Application Ref:	3/2026/0490			 Ribble Valley Borough Council www.ribblevalley.gov.uk
Date Inspected:	11/08/2026	Site Notice:	N/A	
Officer:	LOH			
DELEGATED ITEM FILE REPORT:				APPROVAL

Development Description:	Proposed single storey rear extension
Site Address/Location:	15 Croasdale Drive Clitheroe BB7 1LQ

Drawing Title
Proposed Plan and Elevations

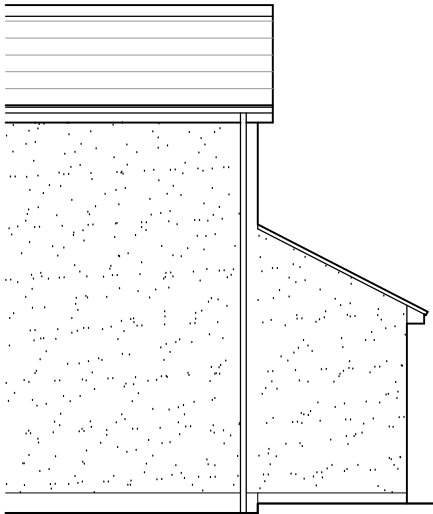
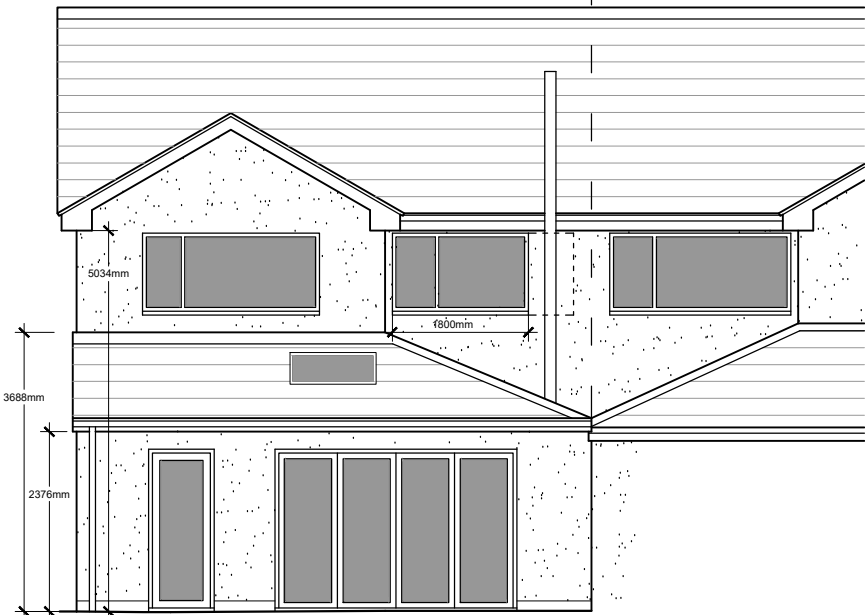
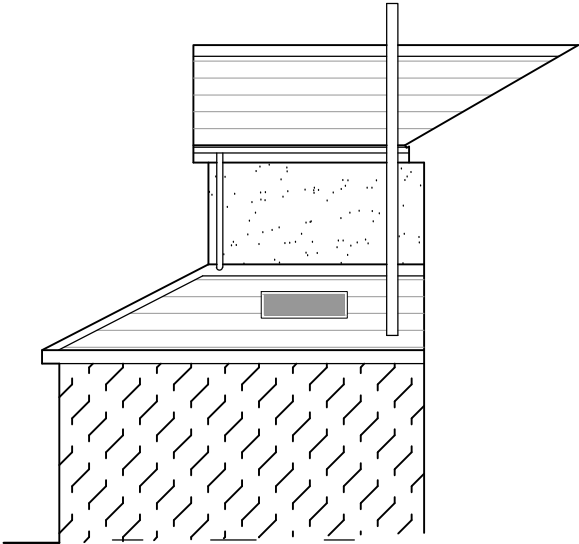
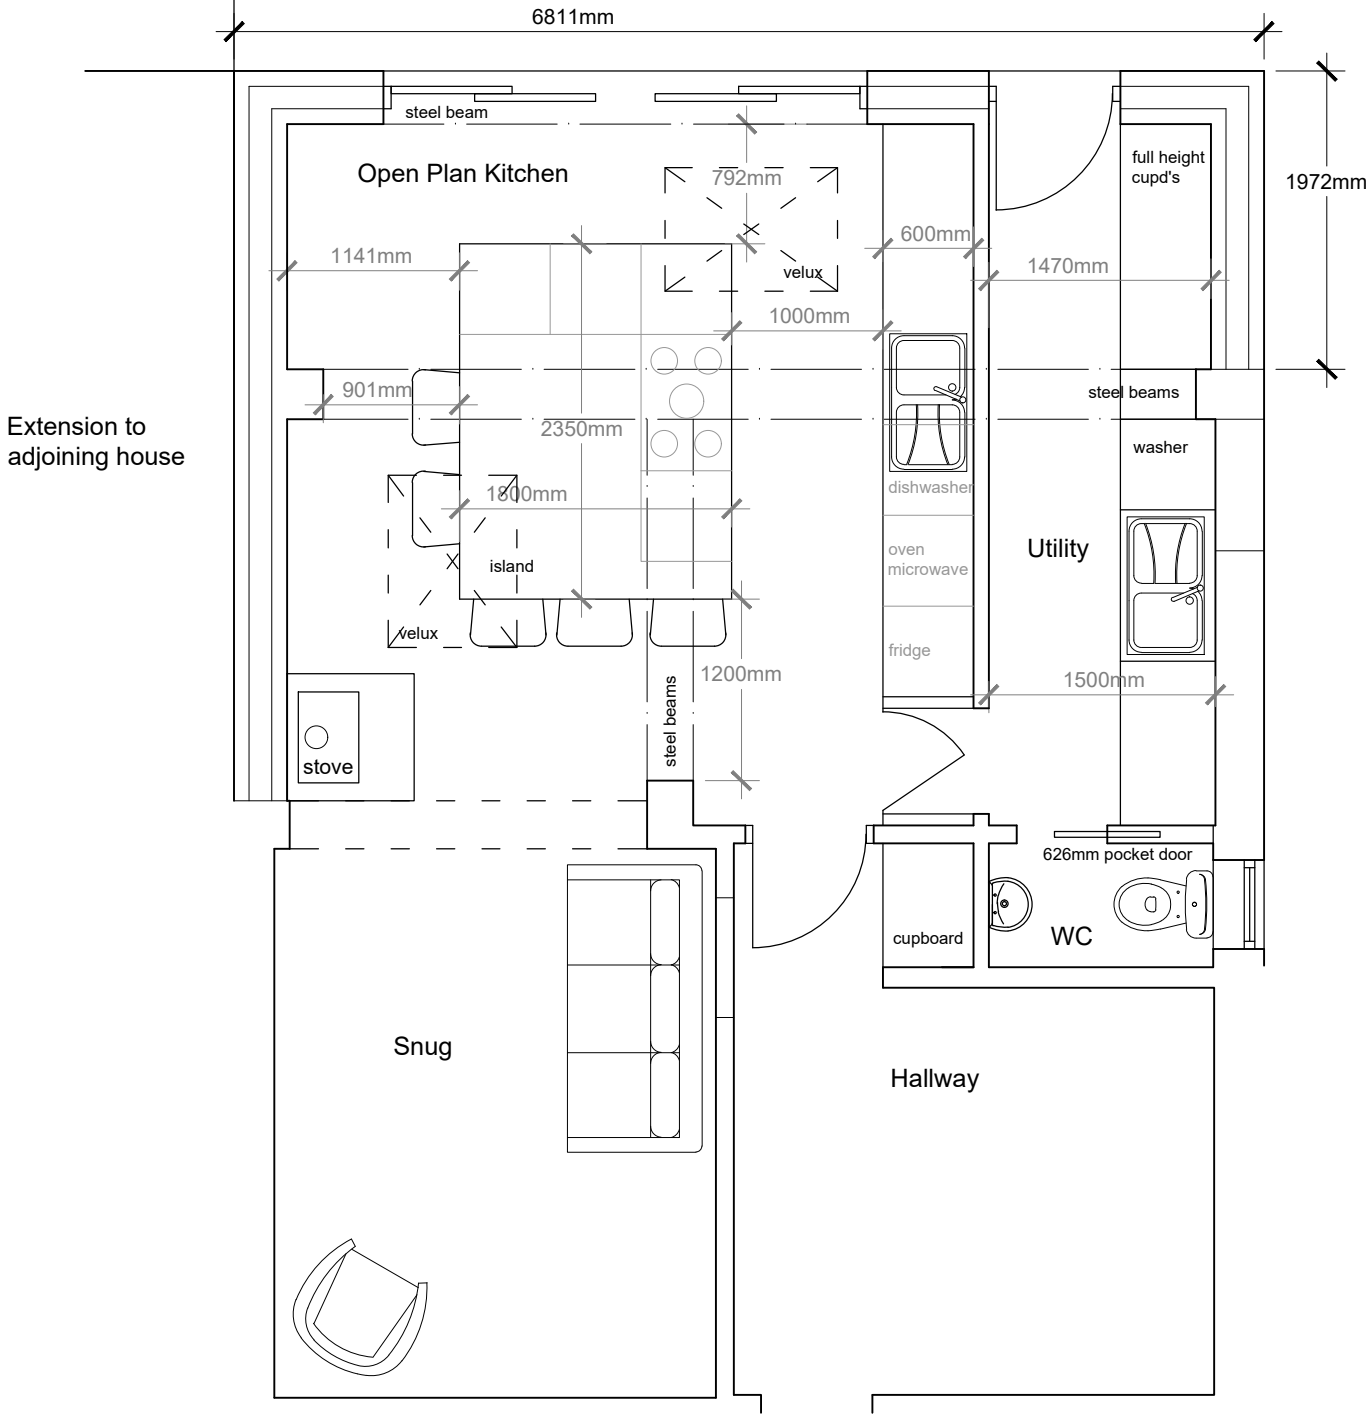
CONSULTATIONS:	Additional Representations.
One letter has been received raising concerns as follows: - the position of the stove flue and proximity to bedroom and kitchen windows. - Stove flue discharging below the main roof ridge line, affecting the neighbours air space, impacting health and the exterior of the house. - Concerns of potential fire risks of flue being situated close to roof and eaves. - Uncertainty over the extension wall and guttering system.

Concerns have been raised regarding uncertainty over the extension wall and guttering system; the submission of the roof plan has provided confirmation that the guttering for the proposed extension is within the boundary line. Further concerns were regarding the position of the stove flue as well as impact on air quality. This would be a matter for building control in terms of installation requirements and environmental health in terms of any resulting impacts from smoke. From a planning perspective the issues relate to impact on visual amenity and in this respect the proposed flue is acceptable.

In respect to scale, the extension is modest in footprint, measuring approximately 4.8m in length at its longest point, and extending the width of the existing dwellinghouse. The eaves will adjoin to that of the neighbouring single-storey extension at No.13 and the roof will be of gabled design, with a ridge height of 3.6m. As such, the extension will match the architecture of the existing dwellinghouse and the neighbouring dwellings and will not read as an incongruous addition to the application site.

In respect of the flue this would be acceptable in this regard.
